Address: 102 Wellington Street Huddersfield HD3 3EP

Application number: 2024/93222	
What is the application for?:	Erection of two storey rear extension with rear dormer
Address of the site or building:	104, Wellington Street, Oakes, Huddersfield, HD3 3EP
Postcode:	HD3 3EP

Revision:		Date:	
<div><div><div>blik</div><div>INTERIOR DESIGN & ARCHITECTURE CONSULTANCY</div></div></div>			
Job title			
104 Wellington Street, Lindley Huddersfield HD3 3EP			
Drawing title			
Proposed Plans .			
Scale	Drawing No.	2425 / 01A	
1:50			
Date			
Oct. 2024			
Drawn by

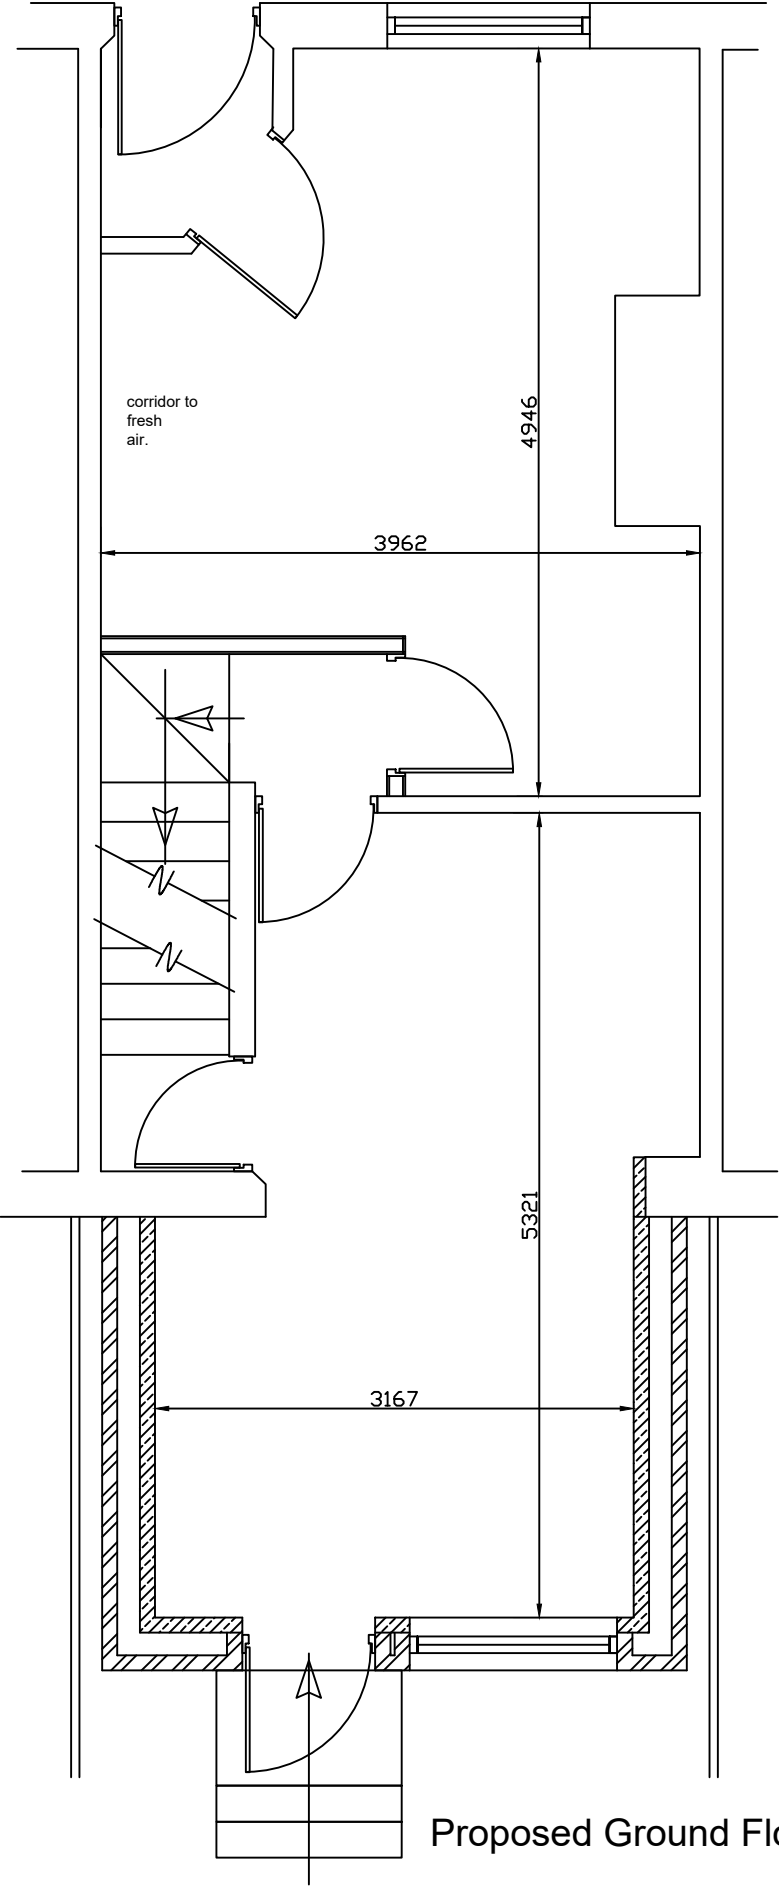
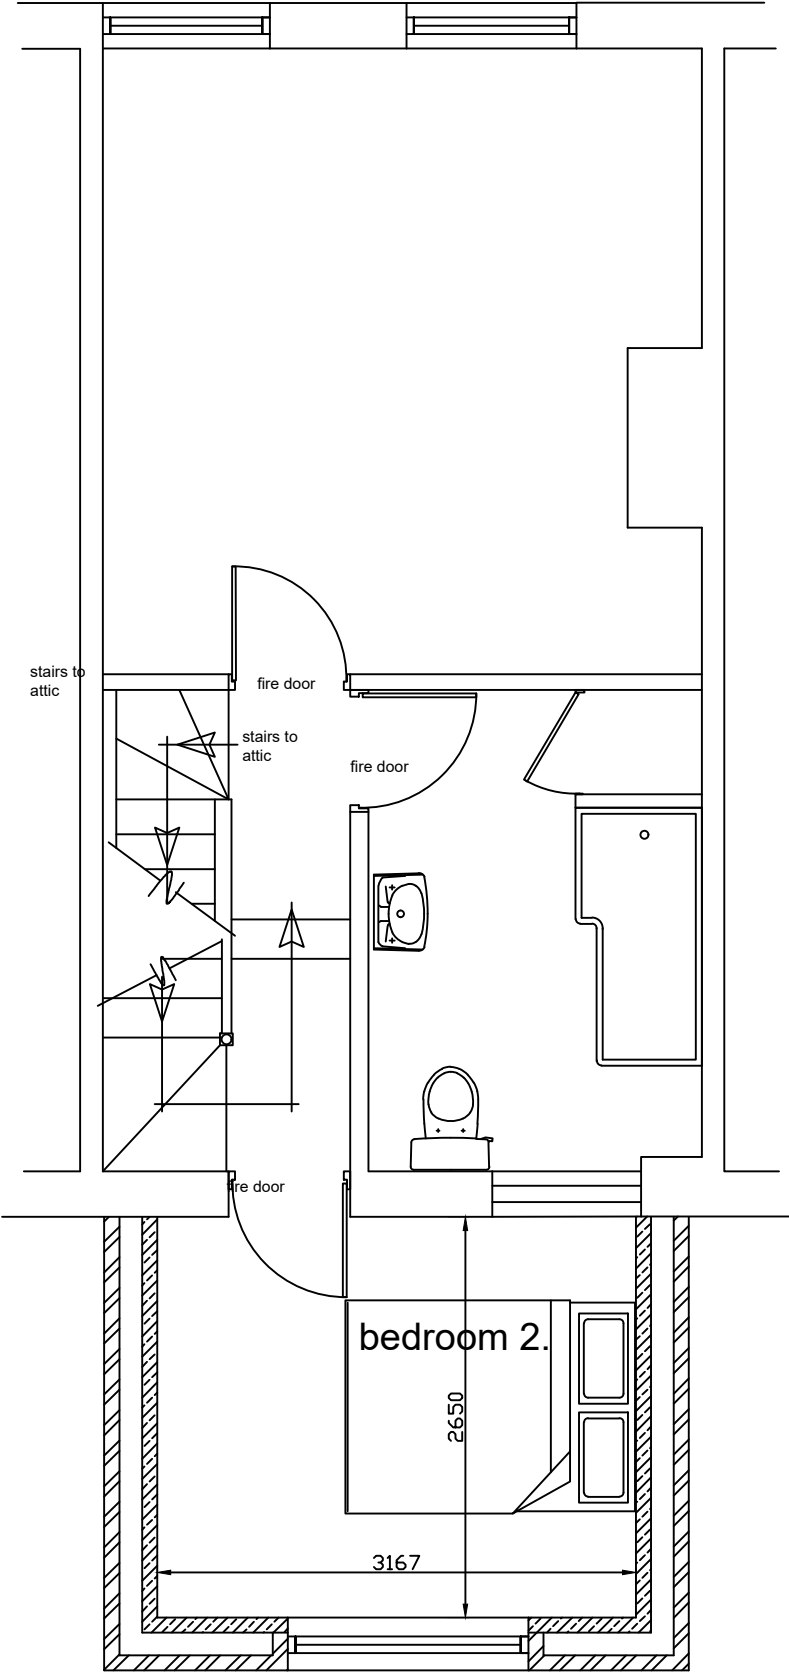
Type of comment: An objection	
Do you wish your comments to be published on the website anonymously?	No
The building of the extension would significantly reduce the amount of daylight coming into our kitchen and rear bedroom windows and this is exacerbated by the fact it is a double height extension. Due to the house being south facing the amount of light into the two habitable rooms is already limited and this double height extension would make this much worse. We also believe the dimensions of the extension would cause it to breach the 45 degree rule.
